Review of Previous Flora and Fauna Reports - Seaforth

RE: Review of Bushfire Protection Assessment report – Seaforth Precinct A1

I have reviewed the Bushfire Protection Assessment for the proposed subdivision of Precincts A1 and A2, Wakehurst Parkway, Seaforth, prepared by Conacher Travers in April 2003.

Aerial photograph of property and surrounds

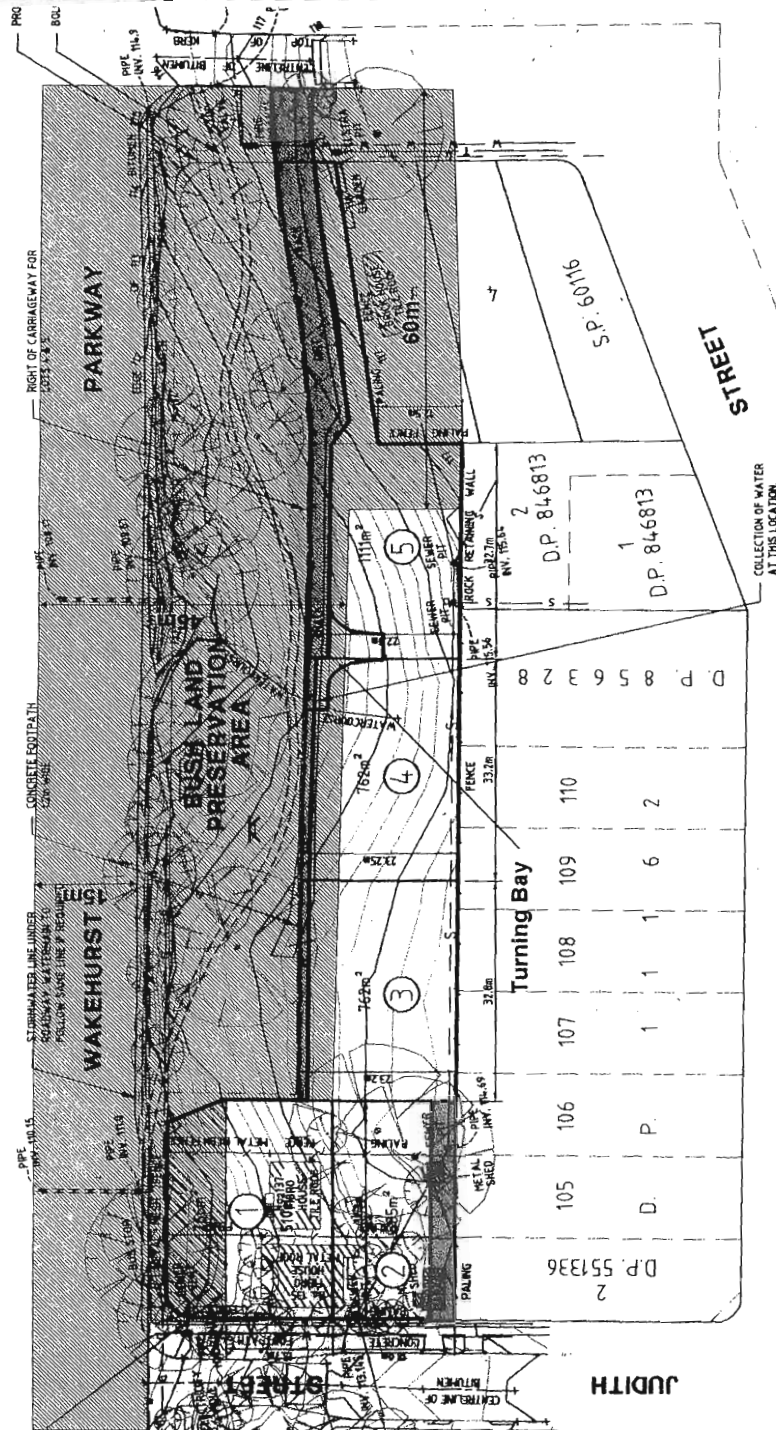
The Bushfire Protection Assessment raises some issues with regard to protection of threatened species on the Precinct A1 site. The report identifies that the whole of the Bushland Preservation Area on the site should be managed as an Inner Protection Zone for bushfire hazard reduction. This is illustrated on Schedule 1.

In general, an Inner Protection Zone should be managed as an almost fuel-free zone. This is usually achieved through a combination of access tracks and roadways, and mown lawn. This management would clearly impact upon the Duffy's Forest ecological community, and also upon the threatened plant species known or potentially present.

More specific details for management of an Inner Protection Zone are provided in Appendix 1 of the Bushfire Protection Assessment report. Trees are permitted within an Inner Protection Zone if the canopy does not form a link with the shrub layer, and at maximum densities specified in Table 2.

I have roughly calculated the densities of existing trees in the Bushland Preservation Area (based on the trees illustrated on Schedule 1, and the boundary of the APZ indicated on Schedule 1), and compared these with densities specified in Table 2:

- there are no trees within the first 5m of the asset protection zone, this being the area from the building zone to the proposed access track. This is consistent with requirements in Table 2;
- there are approximately 3 trees in the next 5m of the APZ (ie between 5-10m from Lots 3, 4 and 5), within an area of approximately 480sqm. This is less than 1 tree per 100sqm;
- there are approximately 6 trees in the next 10m of the asset protection zone (ie between 10-20m of Lots 3, 4 and 5), within an area of approximately 960sqm. This is less than 10 trees per 400sqm.

It appears that no trees will need to be removed from the Bushland Preservation Area for asset protection. However, the actual number and arrangement of trees depends on an individual assessment being undertaken (page 5 of Appendix 1).

In summary, it appears possible that the Bushland Preservation Area could be maintained for the dual purposes of asset protection and threatened species protection. However, this will need to be achieved through specific on-site discussions between an ecologist and an experienced bushfire protection manager. Responsibility for on-going maintenance of the area will need to be addressed.
